Response to Planning Application

Application ref: EP/10/21/PL

Description: Demolition of an existing garage & erection of 2 No. 2 bed dwellings (resubmission following EP/115/20/PL). This site is in CIL Zone 4 and is CIL Liable as dwellings.

Location: 4 Beechlands Close & east of 18 Montpelier Road East Preston BN16 1JZ

18 BEECHLANDS COURT, EAST PRESTON, BN16 1JZ	
Client	Description
c/o RSP ARCHITECTS LTD	PROPOSED SITE PLAN

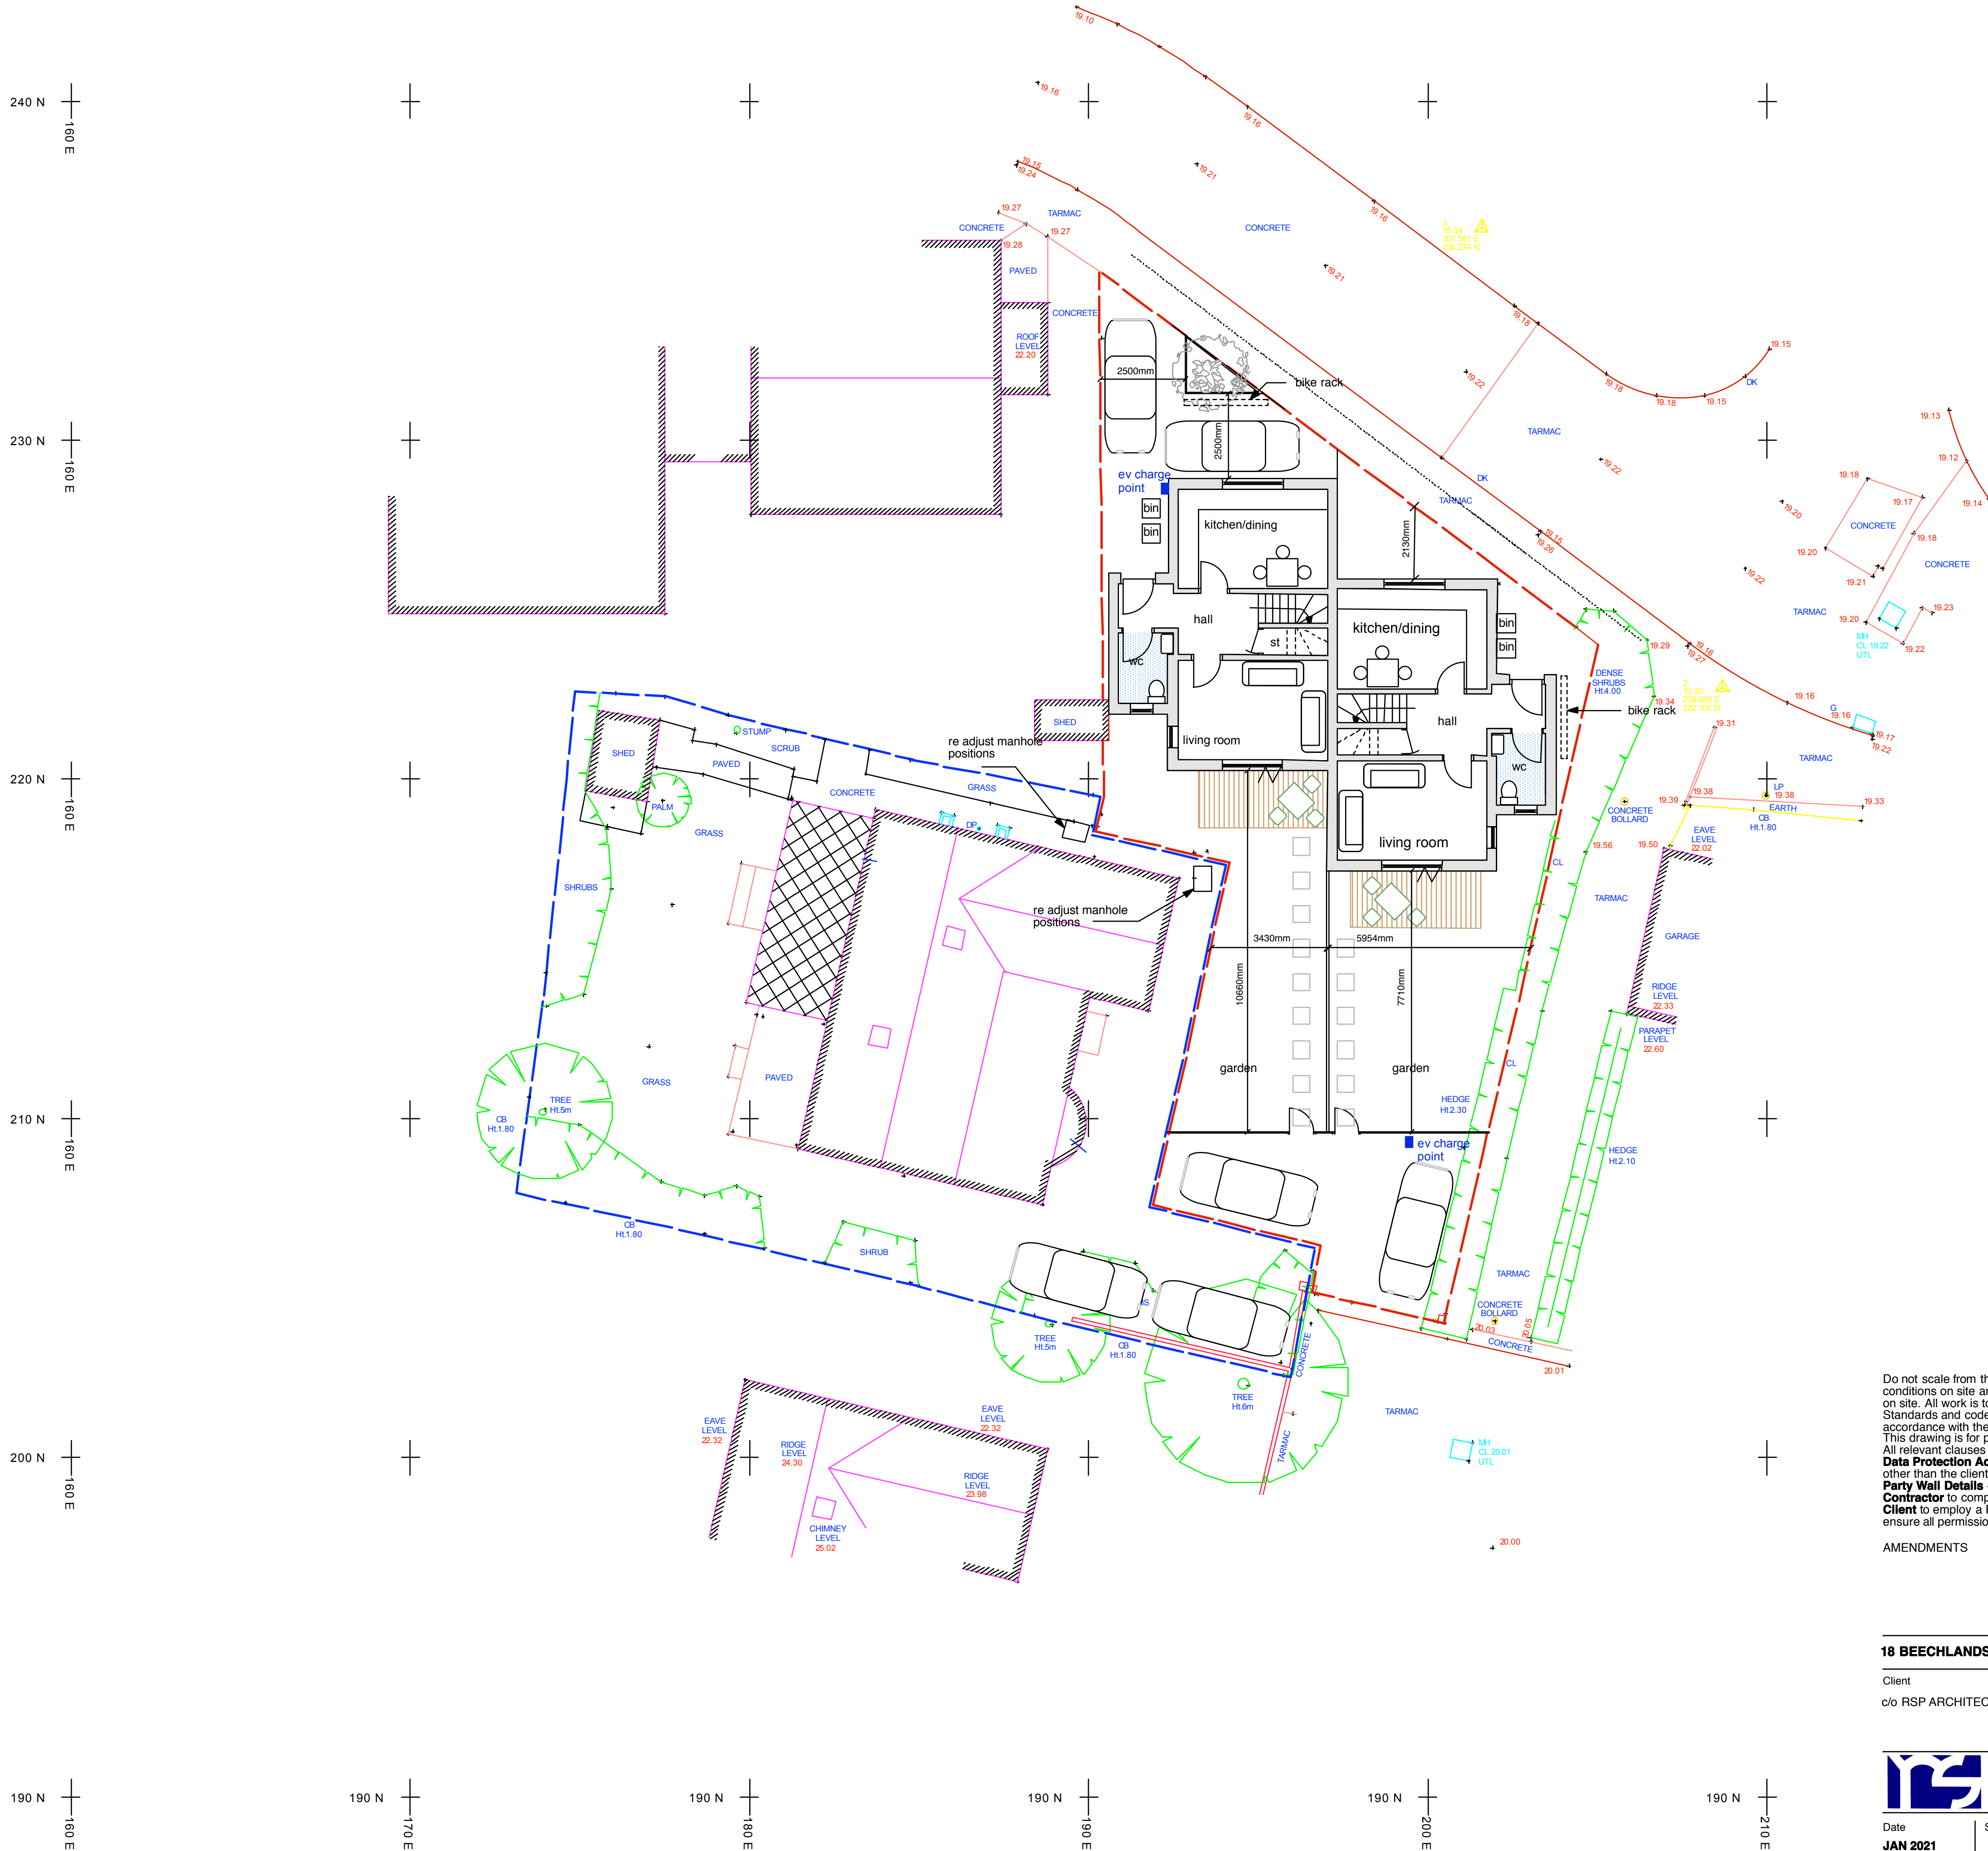
The proposals appear to suggest an over development of this garden plot with layout, access and resulting usable garden space. Consideration should be given to adjacent dwellings and the impact the proposals will have on street scene in this residential area. Existing trees to adjacent properties which fall beyond the red line site whose roots and canopy fall within the development site would be impacted by the proposed development.

The proposals as shown, if approved, will need further landscape details to be submitted in the form of a detailed planting plan and specification detailing species choice, actual plant quantities, planting densities and size at time of planting. Detail should also be provided regarding existing trees and boundary planting including the existing trees and shrubs to be removed and retained. Planting would be required to offer screening to adjacent neighbours.

The recommendation is that this appears to be an over development of this garden plot and therefore not compliant with Aruns Design Guide 2021. Details have not been provided with this application re the existing trees and hedging which may be effected by the proposals and no landscape scheme has been submitted for landscape mitigation following loss of this garden space. Biodiversity net gain has also not been demonstrated. Greenspace would **recommend an objection** to the development proposals in this application EP/10/21/PL as detailed above.

Landscaping would need to be provided demonstrating a biodiversity net gain on completion. All proposed planting should consider the setting of these proposals and the neighbouring properties in this location. Trees, shrubs and ornamental planting would need to be specified at a size to allow instant impact, but which would establish and mature as the site develops.
